# Rezoning Transportation Analysis

Petition Number: 2021-096

**From: Brandon Brezeale, PE**

Date	Description
8-20-2021	First Review (DBS)
9-17-2021	Second Review (WB)
10-19-2021	Third Review (PDM)
11-22-2021	Fourth Review (AO)

SHEET TITLE: TECHNICAL DATA
 SHEET NUMBER: RZ-1

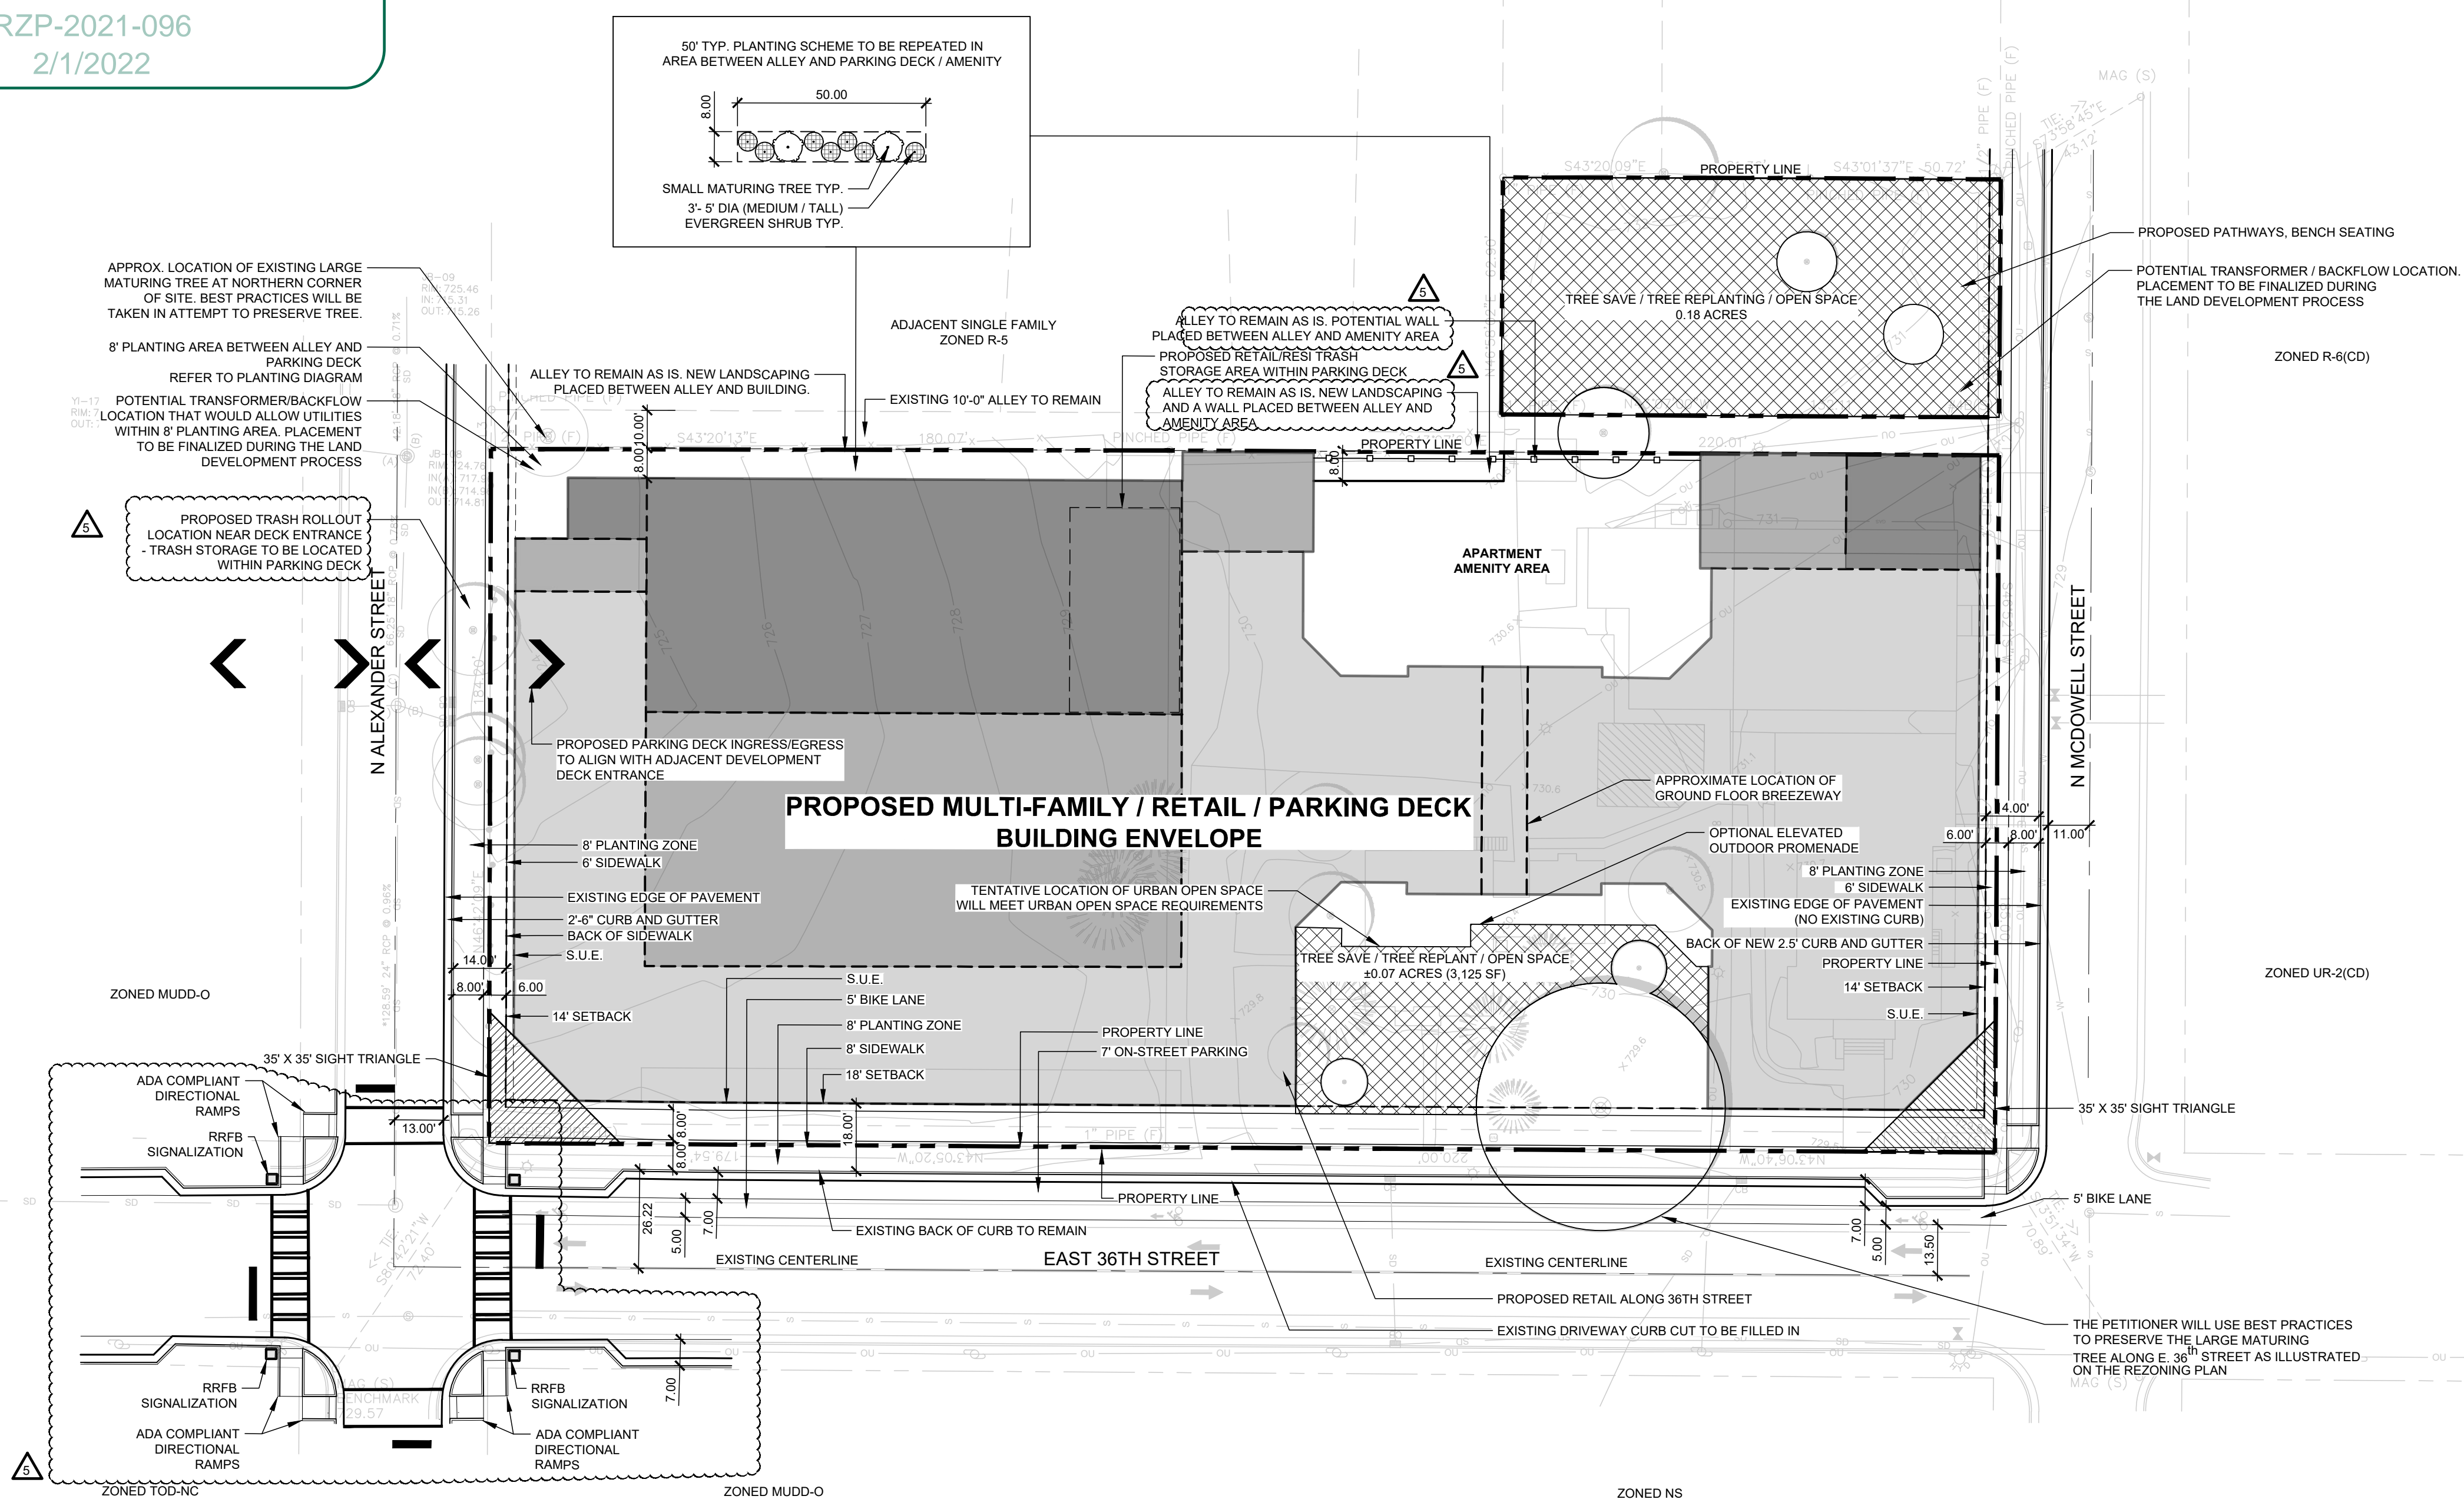
- ~~2. Revise site plan to reflect 10' x 10' sight triangles at the intersections of East 36<sup>th</sup> Street with North Alexander Street and North McDowell Street.~~

- ~~3. Revise site plan to indicate two curb ramps at the intersections of East 36<sup>th</sup> Street with North Alexander Street and North McDowell Street.~~

- ~~4. Revise site plan to indicate proposed access point(s).~~
- ~~5. Revise site plan to include dimensions of bike lane and on-street parking. Cross-section needs to be symmetrical from centerline street (bike lane and on-street parking on both sides)~~

- ~~7. Revise site plan to show replacing valley gutter on the North Alexander Street frontage with standard 2'6" curb and gutter to match the curb on the opposite side of North Alexander Street.~~

8. ~~Revise site plan to construct bulb-outs on East 36th Street at the corners of at North Alexander Street and North McDowell Street. Provide recessed on-street parking on North Alexander Street and North McDowell Street as SHOWN in the graphic below. New comment in response to request from Noda Neighborhood Board.~~

**Outstanding Comment from 10-19-2021:** Revise site plan to construct curb bulb-outs on all corners of East 36th Street and North Alexander Street.
